Consultation Response from: KC Environmental Health (Pollution & Noise Control)
2019/93903 - 122A Laund Road, Salendine Nook, Huddersfield, HD3 3TY
Erection of one dwelling and associated works
Date Responded:
14 Feb 2020
Responding Officer:
Richard Hume
Responding Ref:
WK/2004024
Contaminated Land

**Figure 2: Water Level to Barometric Pressure Ratio Plot**

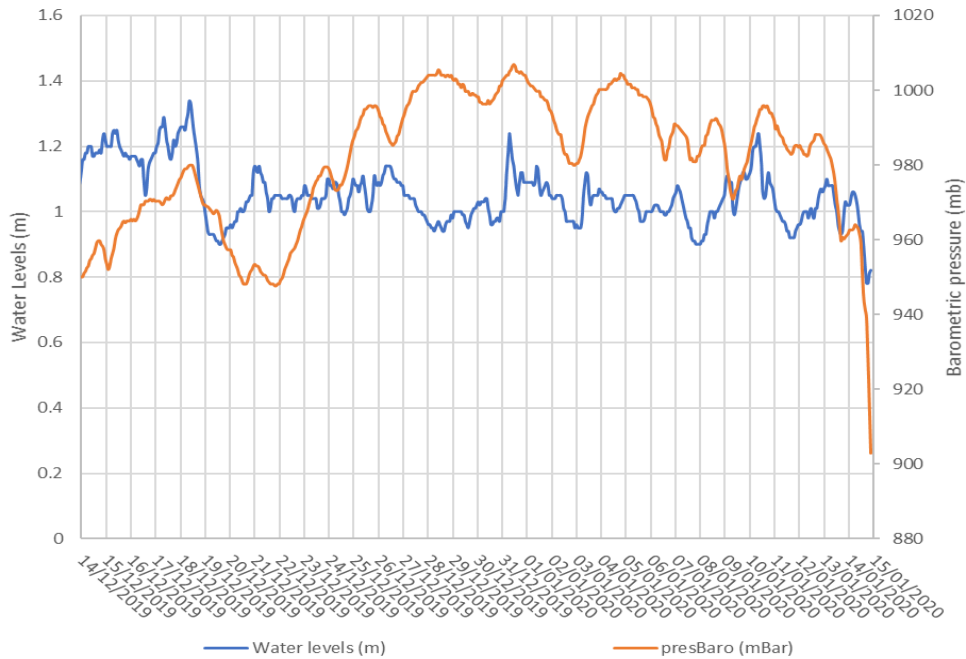
The submitted report provides details of the water levels in WS302 where the continuous monitoring was carried out. It is noted from the report that the monitoring well response zone was between 1.0 and 2.0m bgl and that throughout the monitoring period the water level was between 0.78 and 1.34m (from Table 1 and the raw data in appendix 1) or 0.78 and 1.18 (from Figure 2). The raw data advises that the average water level was 1.05m. It appears from this data that at least 66% the response zone was submerged under water for the whole monitoring period and completely submerged for a significant proportion of the monitoring period. The report fails to make comment on this or consider the significance of this. Also, the atmospheric pressure and water levels for the one day monitoring at WS301 are not provided and not considered in the report. In addition, the previous and latest ground gas monitoring results both show that there are elevated levels of carbon dioxide within around 40m of the building that the application relates to, the significance of this also needs to be considered.
